From: Jonathan Best <Jonathan.Best@arun.gov.uk>
Sent: 25 March 2026 16:29
To: Planning.Responses <Planning.Responses@arun.gov.uk>
Cc: Simon Davis <Simon.Davis@arun.gov.uk>
Subject: BE/15/26/PL

Land East of Heath Place Bersted PO22 9SL.

I have reviewed this application with regards to ecology and Biodiversity Net Gain.

PROPOSED North West Elevation
1:100

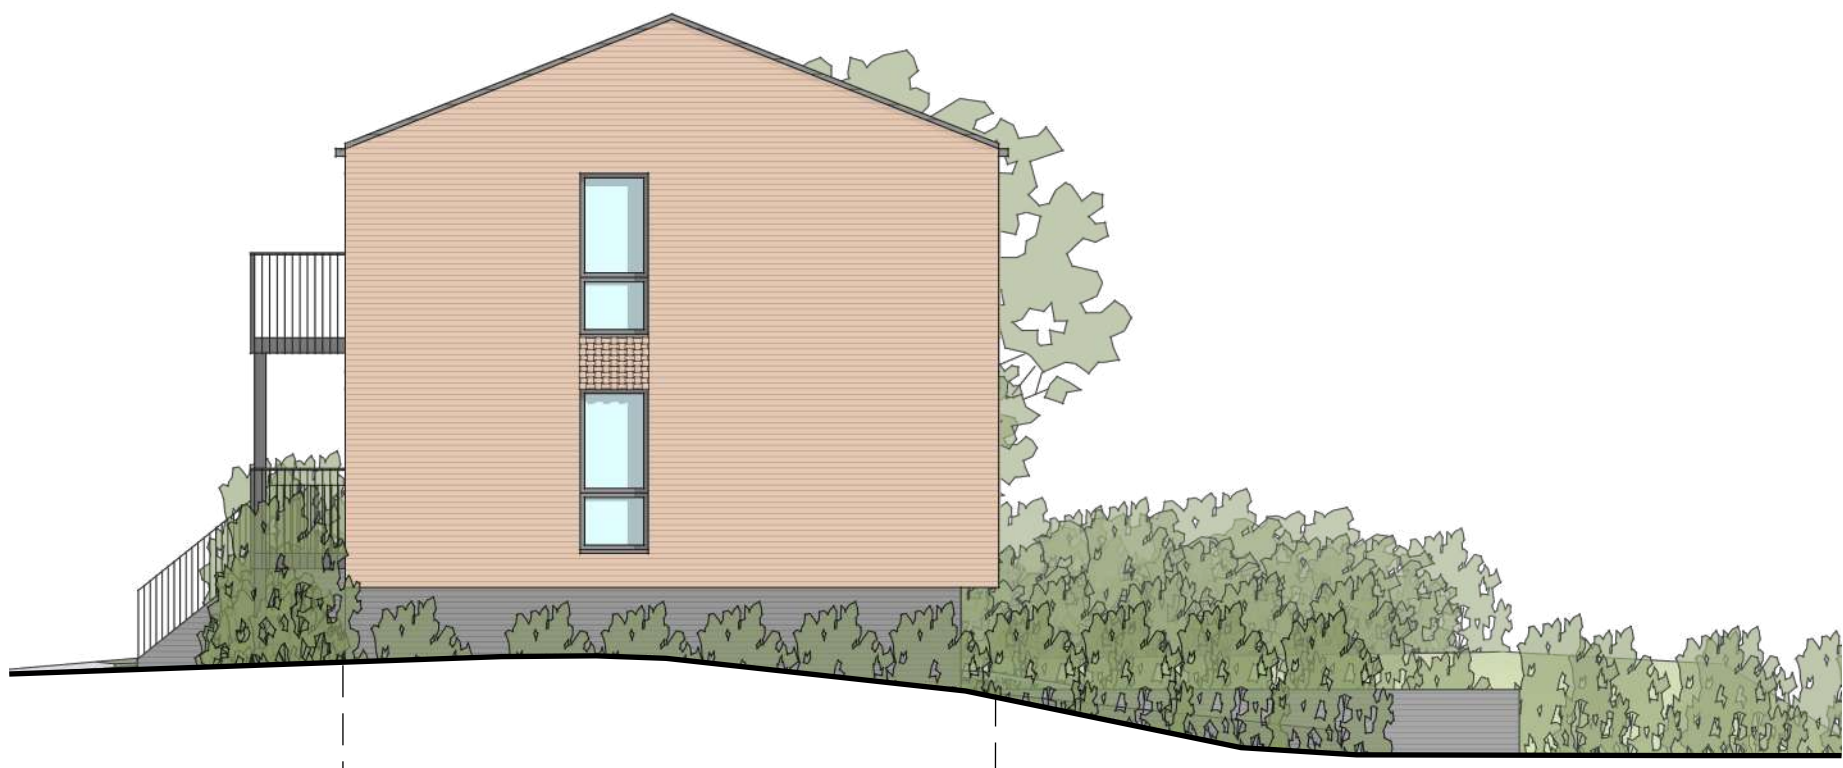
The new flats could incorporate ecological features to provide enhancement for biodiversity. Integral swift bricks on the northeast elevation and integral bat bricks/tubes on the southwest elevation are advised.
